**MODIFICATION REQUEST:
61 Mobbs Lane, Epping (former Channel 7
site)
(MP08_0258 MOD 2 and 3)**

- MOD 2 – Tree Removal
- MOD 3 – Subdivision Amendments

Director-General's
Environmental Assessment Report
Section 75W of the
Environmental Planning and Assessment Act 1979

August 2011

TITLE
CONCEPT PLAN - COMMUNITY TITLE DEVELOPMENT
AT MOBB'S LANE, EPPING

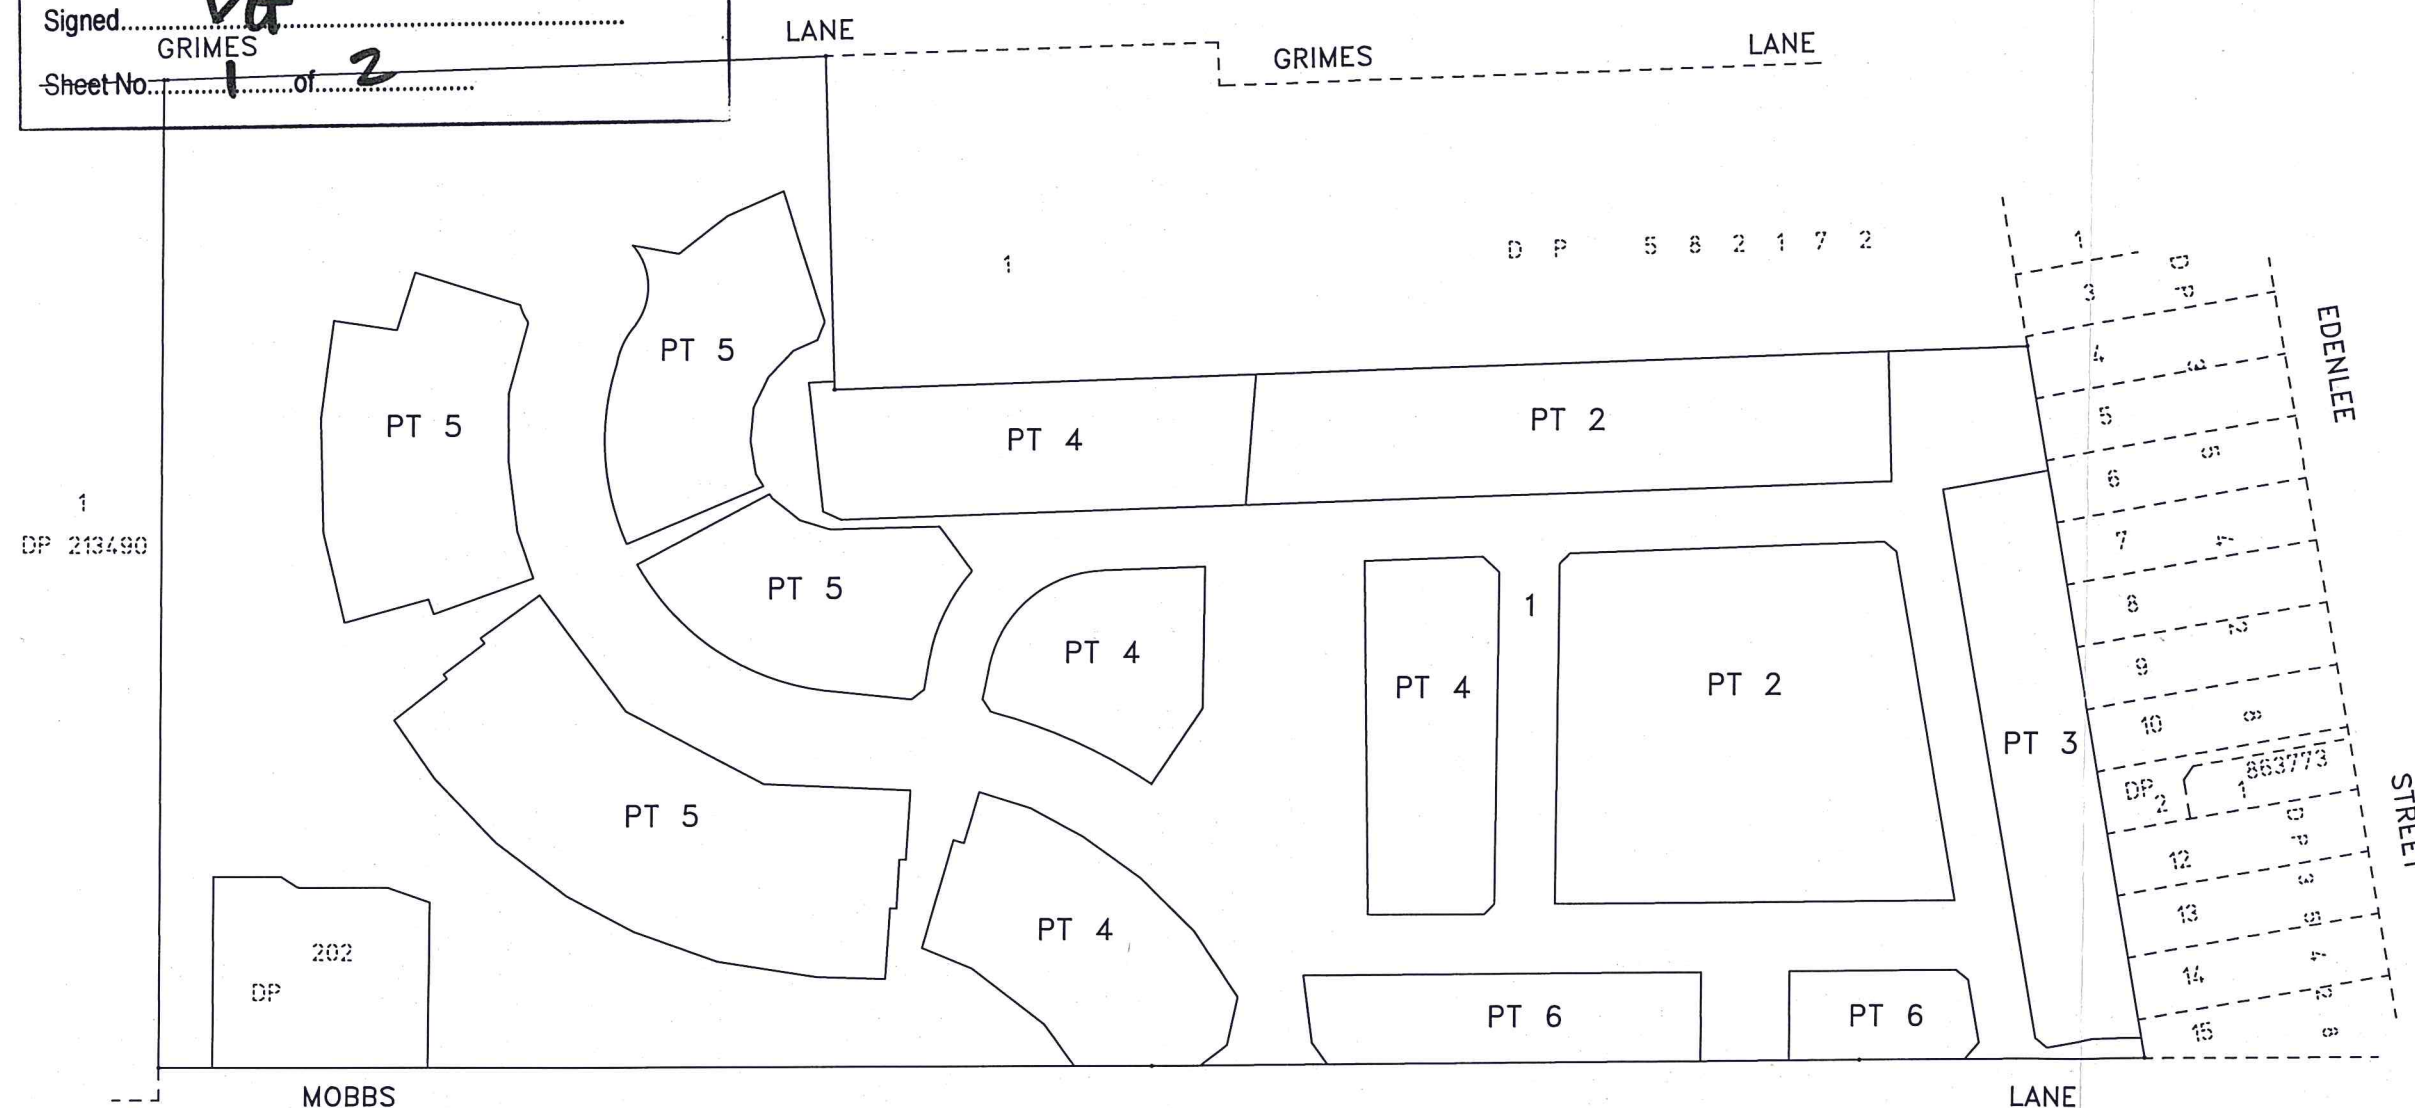
Modification 3 seeks approval for subdivision amendments to clarify the future staged community titling of the approved residential development that is currently under construction. The four community title subdivision plans approved under MP08_0258 are to be replaced with one staged community title subdivision plan. The modification also includes the first stage of the community title plan that reflects the current road works approval and boundaries pertaining to buildings 1, 2, 3, 4, 5, 6, 7 and 8.

Modification 3 proposes the replacement of four existing concept community title subdivision plans into one detailed community title subdivision plan and to allow for staged subdivision within the development. Modification 3 also proposes the Stage 1 community title subdivision plan for the site.

The proposed amendments to the approved subdivision are considered to be consistent with the intent of the original approval and will provide clarity in terms of future staged subdivision of the approved residential development. In this regard, no objection is raised to Modification 3.
